**RE:** Arroyo Vista Apartments  
Grading and Drainage Plan  
Engineer's Stamp Date 2-6-2017 (File: G16D153)

Based upon the information provided in your submittal received 2-8-2017, the above referenced Grading and Drainage Plan cannot be approved for building permit until the following comments are addressed:

**Re: Arroyo Vista Apartments  
4201 Bryn Mawr Dr. NE  
Traffic Circulation Layout  
Architect's Stamp 11-04-16 (G16-D0153)**

sheet no: TCLI

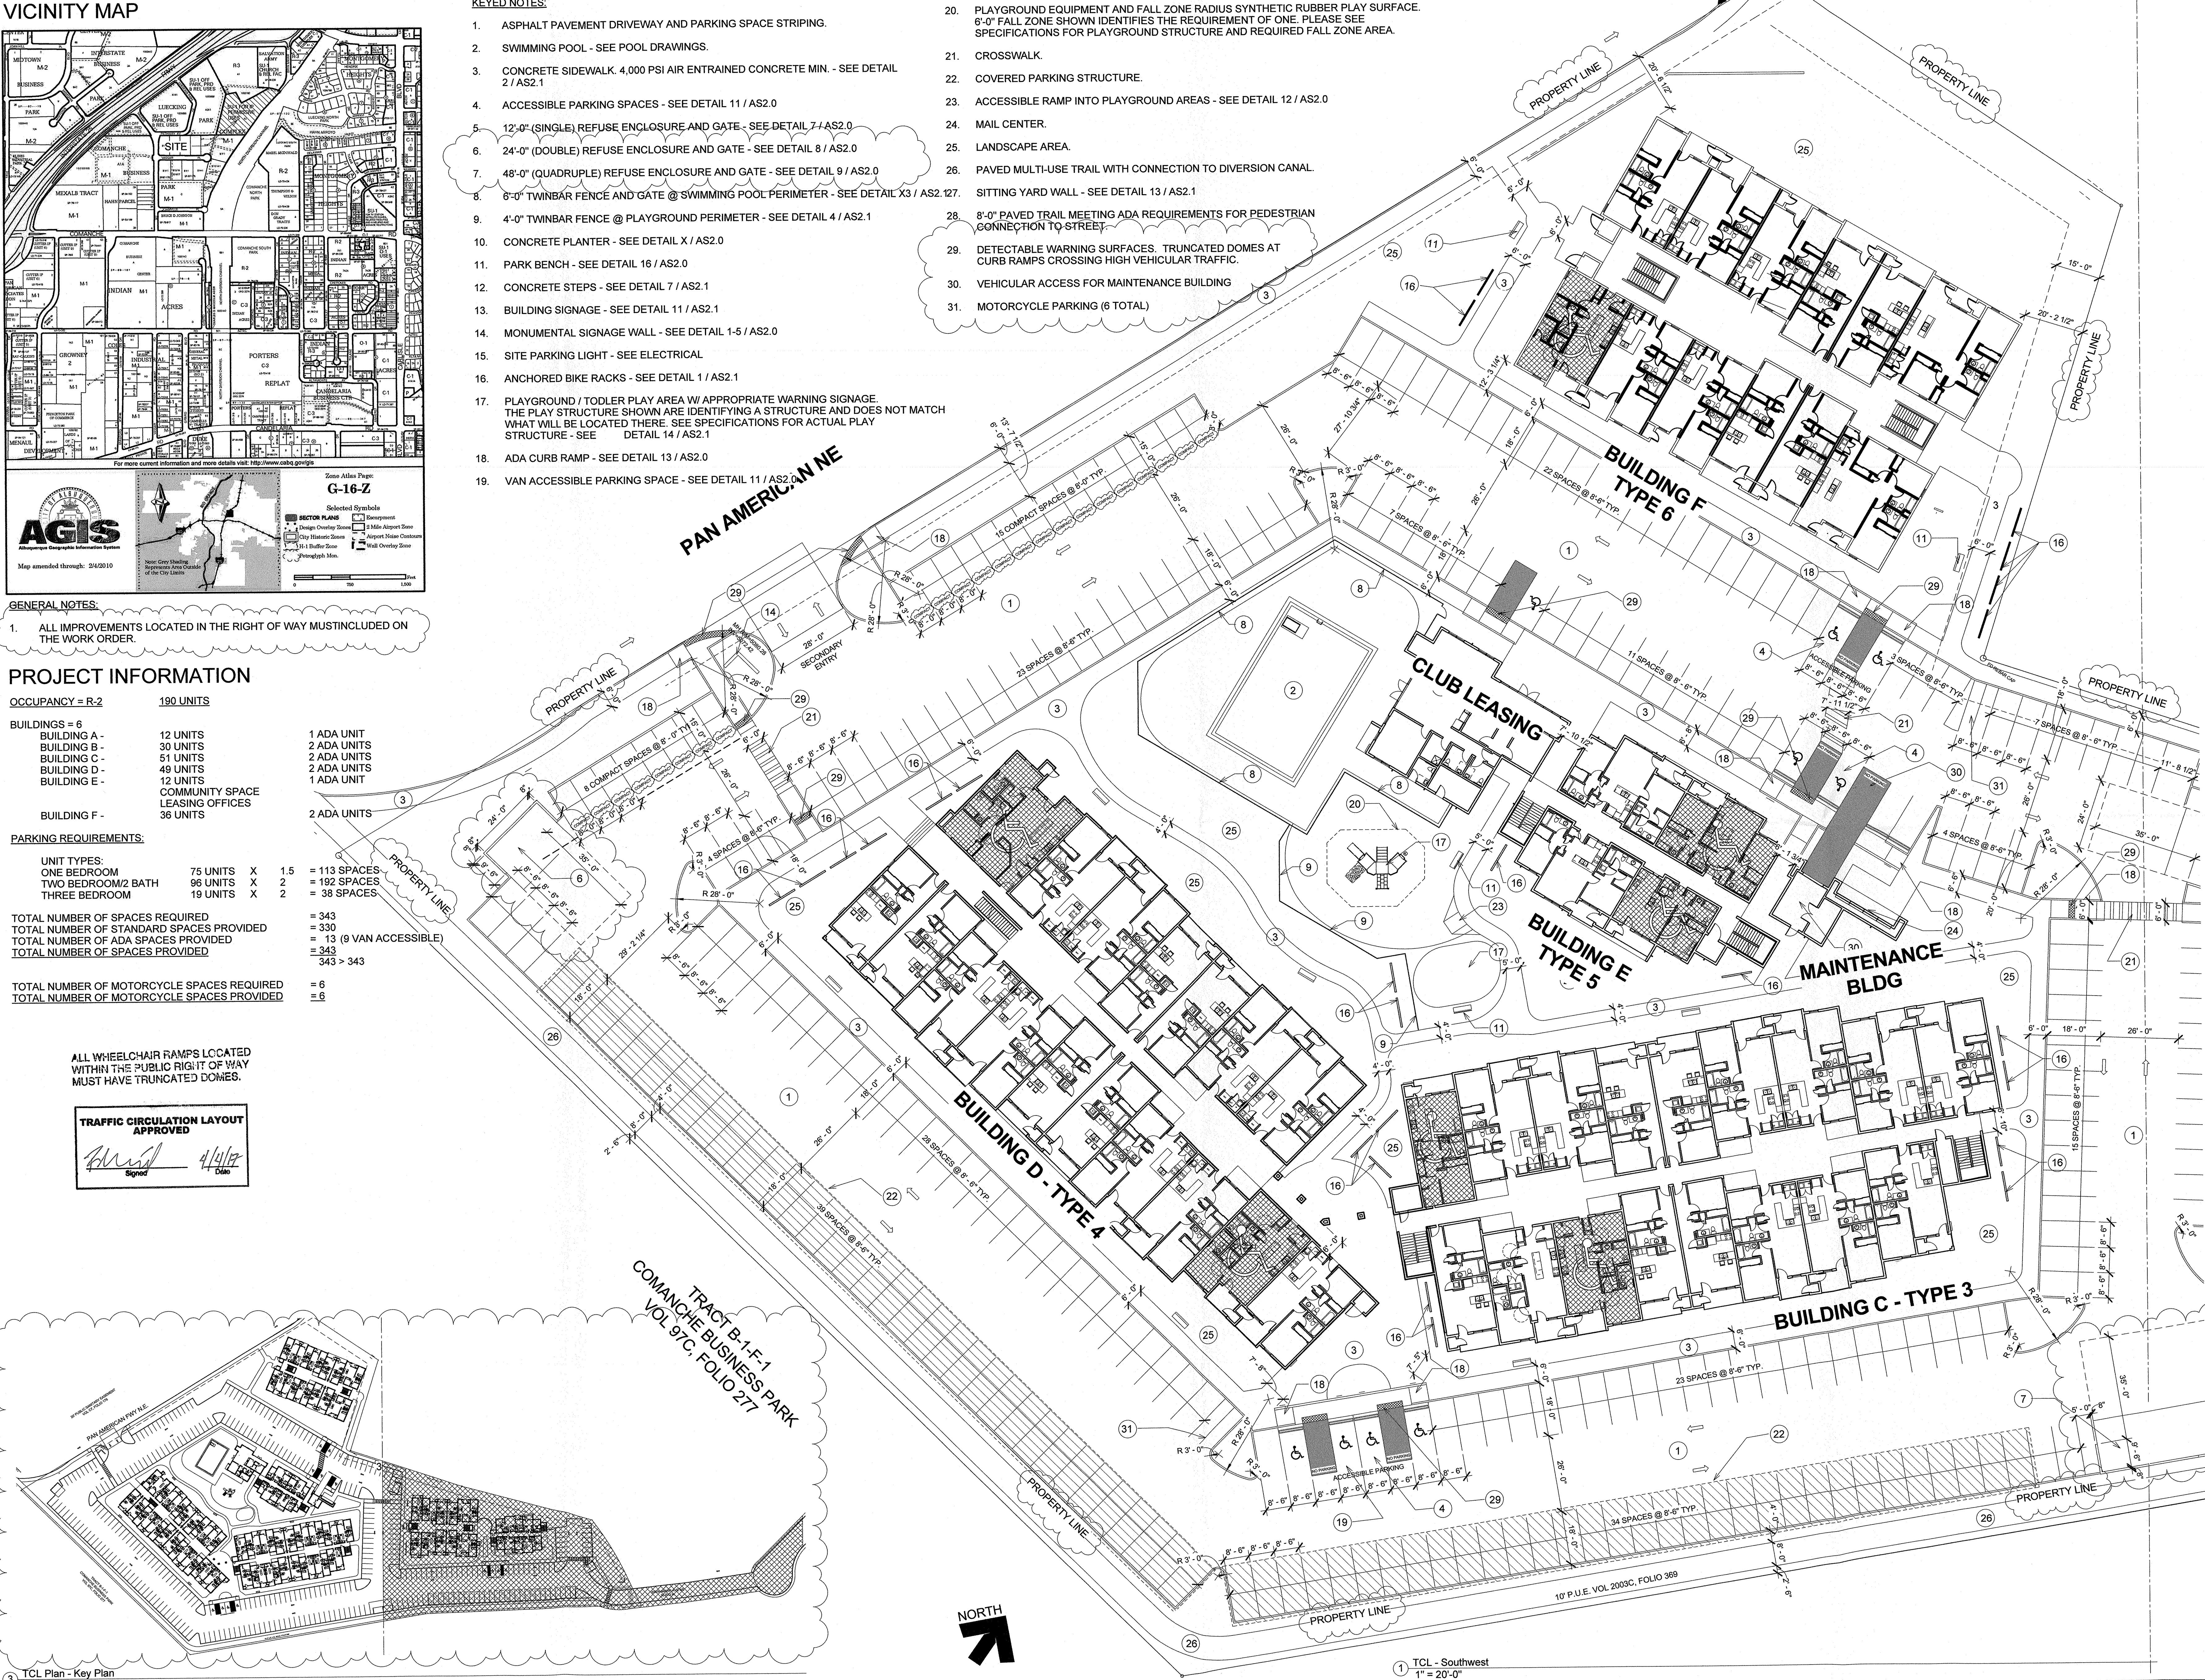
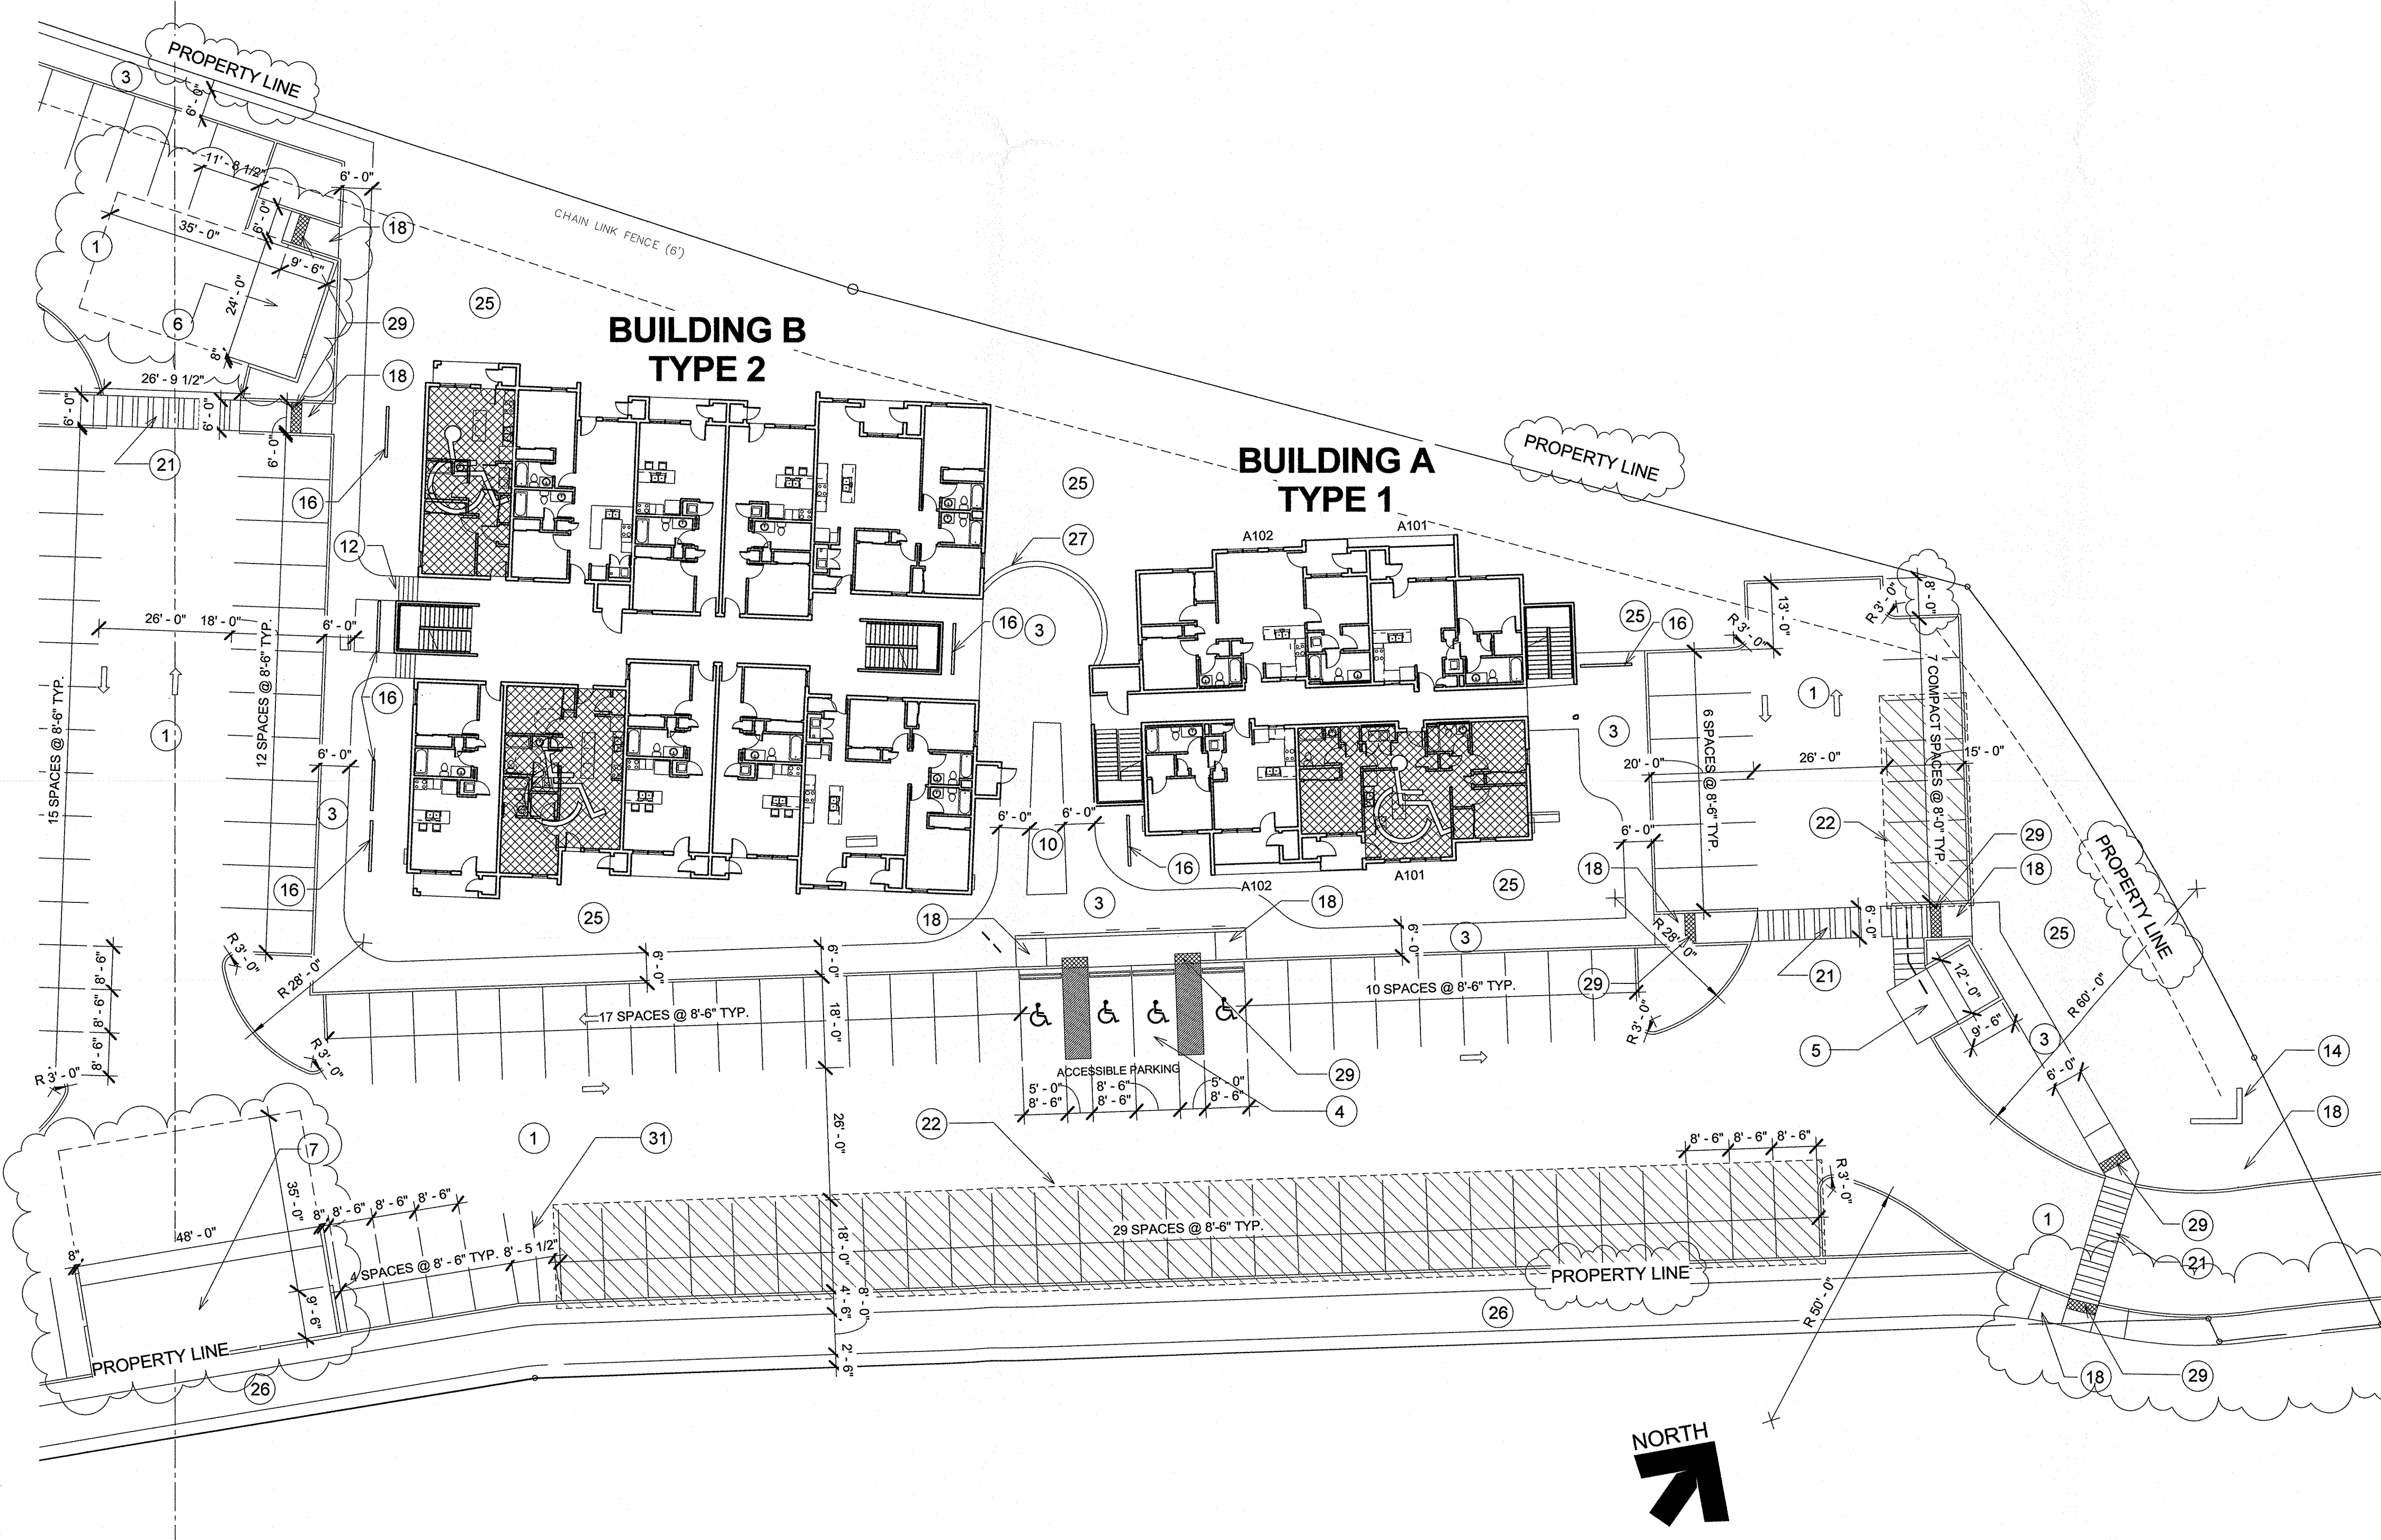
2. Identify all existing access easements and rights of way width dimensions. Please provide an exhibit for all accesses to site.
3. Identify the right of way width, medians, curb cuts, and street widths on Pan American NE and Bryn Mawr Dr. NE. Correct the road name Pan American Fwy NE to Pan American NE.

4. Clarify existing property lines and proposed property lines. Also include any easements existing or proposed.
5. Use match lines on plans to show continuation on second page.

9. Please dimension all pedestrian path ways and crosswalks. Some dimensions are not shown. Add ADA note referring to cross and running slopes for pedestrian paths. The site looks to have large grade changes.

11. Clarify connection to Maintenance building between the handicap parking.

12. Dimension the drive aisle width off of Bryn Mawr.
13. List radii for all curves shown; for passenger vehicles, the minimum end island radius for passenger vehicles is 15 ft. Radius for delivery trucks, fire trucks, etc. is 25 ft. or larger. The secondary entrance could use a larger radius than 12 feet.

14. A 5 ft. keyway is required for dead-end parking aisles. Please add dimensions on the TCL.
15. Per the zoning code, a 6 ft. wide ADA accessible pedestrian pathway is required from the public sidewalk to the building entrances. Please clearly show this pathway and provide details.

16. Per DPM, a 6 ft. wide ADA accessible pedestrian pathway is required from the HC parking stall access aisles to the building entrances. Please clearly show this pathway and provide details.

19. Please add a dotted line type showing how ADA pedestrians will access ADA units.
20. All sidewalks along streets should be placed at the property line. Provide a sidewalk easement if this is not possible.

2 ADA Parking Detail
1/4" = 1'-0"

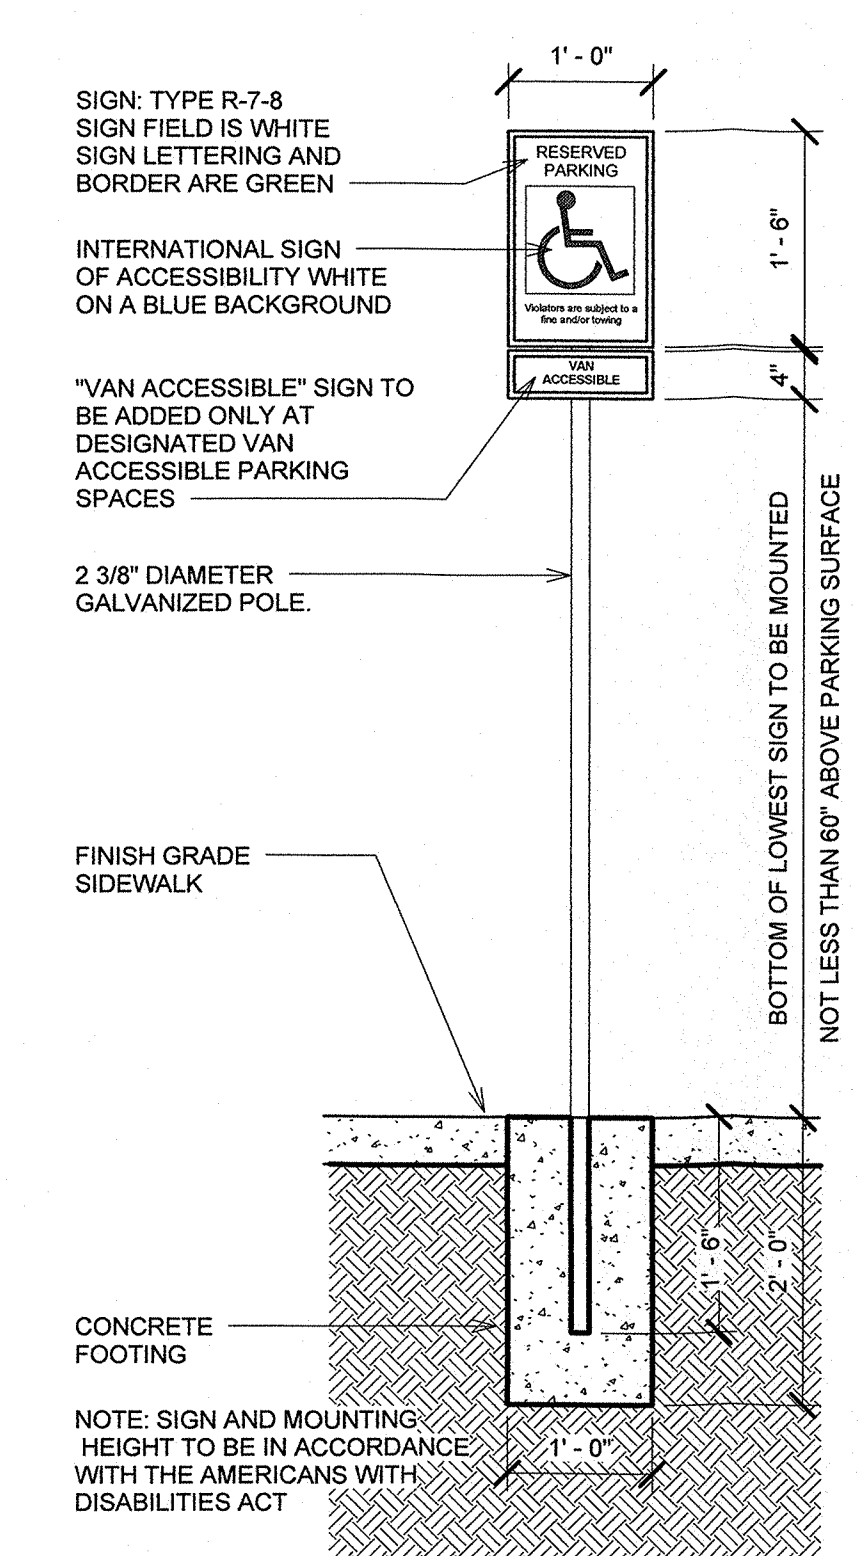
6. Label the compact parking spaces by placing the words "**COMPACT**" on the pavement of each space.
7. The ADA access aisles shall have the words "**NO PARKING**" in capital letters, each of which shall be at least one foot high and at least two inches wide, placed at the rear of the parking space so as to be close to where an adjacent vehicle's rear tire would be placed. (66-1-4.1.B NMSA 1978)

8. The ADA parking space has a clearly visible, blue, International Symbol of Accessibility painted on the pavement at rear of the space (66-1-4.1.E NMSA 1978) or MUTCD recommends a white symbol on a blue background.
